REPORT UPDATE

Application No: EP/64/09/

PLANNING APPLICATION REPORT**REF NO:** EP/64/09/**LOCATION:** Seacot
South Strand
East Preston**PROPOSAL:** Amendment to previously approved planning permission EP/137/03 for extension to existing bungalow**SITE AND SURROUNDINGS**

DRAWN RG APRIL 09
 SCALE 1:100@A3
DRG No. P-01

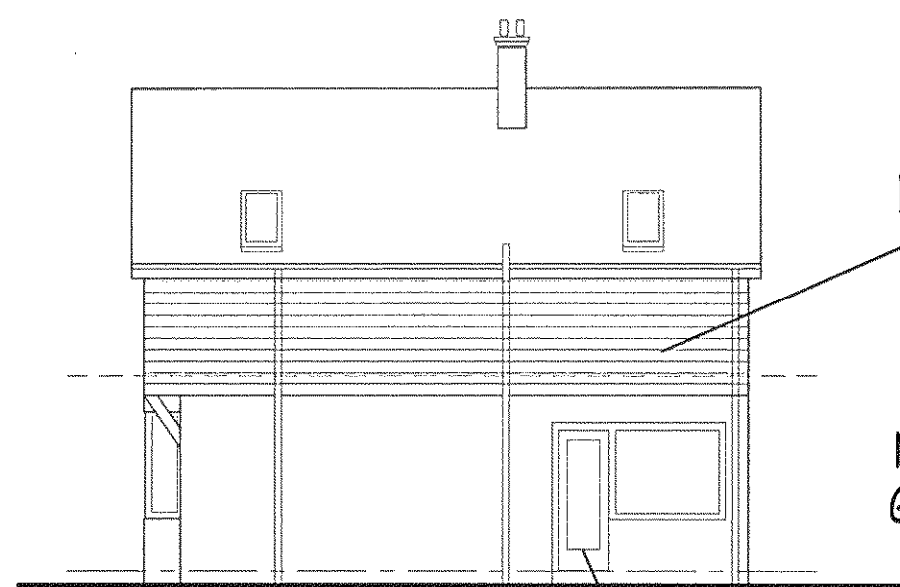
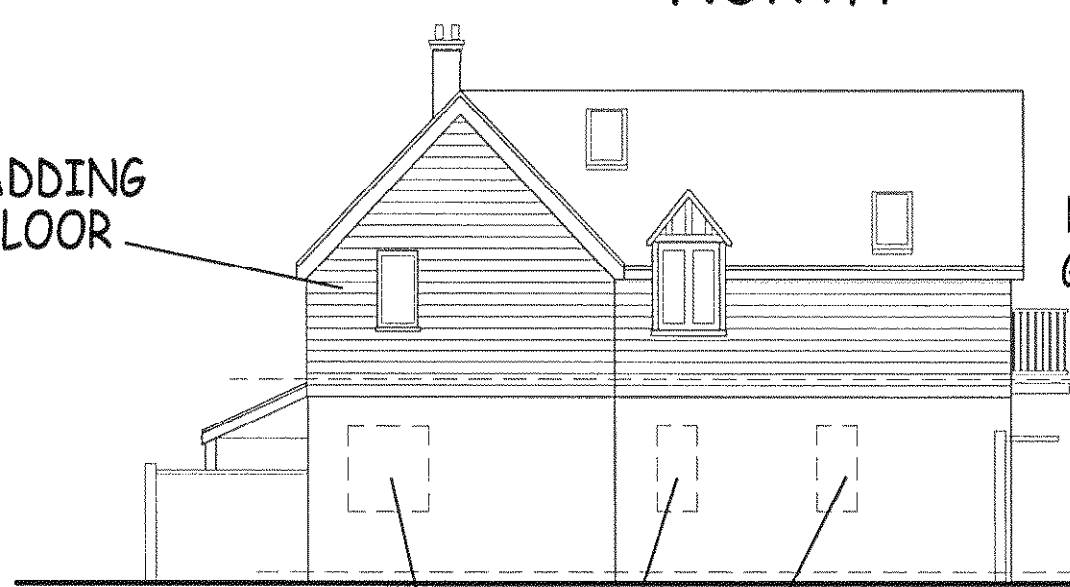
DESCRIPTION OF APPLICATION	The retrospective amendments from the previous approval relate to the number of the roof lights; the relocation of a door from the north elevation to the west elevation; a deeper balcony on the east elevation and cladding in lieu of tile hanging to the elevations at 1st floor level.
SITE AREA	Approximately 149 square metres.
RESIDENTIAL DEVELOPMENT DEN	N/A
TOPOGRAPHY	Predominantly flat
TREES	None affected by the proposed development.
BOUNDARY TREATMENT	Hedging to the east side approximately 1.8m high. Wooden fencing on eastern boundary, approximately 1.8m high. Northern boundary fronts the highway.
SITE CHARACTERISTICS	Detached 2 storey property. Render and wooden cladding elevations, gabled roof. Open porch on north elevation.
CHARACTER OF LOCALITY	The site is located within a residential area. Mix of types and styles of properties within close proximity of the site.

Roof lights within the west elevation overlook 'Chance Cottage'. Conditions for obscure glazed windows and materials from the previous application EP/137/03 have not been met. Balcony of 'Lovely Cottage' is directly overlooked by one of the bedroom windows. Roof lights on the western elevation are larger than the proposed plans. Original Edwardian appearance of the house has been lost. Supplementary plans are inaccurate.

East Preston and Kingston Preservation Society: The timber cladding is incompatible with the existing house and surrounding buildings. Applicant should be required to remove the cladding and complete the house to its original design.

Comments noted. It is considered prudent to repeat the conditions as formerly applied to EP/137/03. The roof lights within the western roof elevation are approximately 1.8m to sill height and will therefore not result in unacceptable overlooking of neighbouring properties. The additional roof light in the south elevation is set high in the roof and thereby would not result in unacceptable overlooking of neighbouring properties. The timber cladding used within the construction is considered to be an acceptable use of material within the street scene.

- 1 Within 2 months of the permission hereby granted the bedroom window at first floor level on the south elevation of the dwelling shall at all times be glazed with obscured glass.

- 2 This permission relates to the plans as submitted and amended by substitute elevation plans dated 30-06-2009.
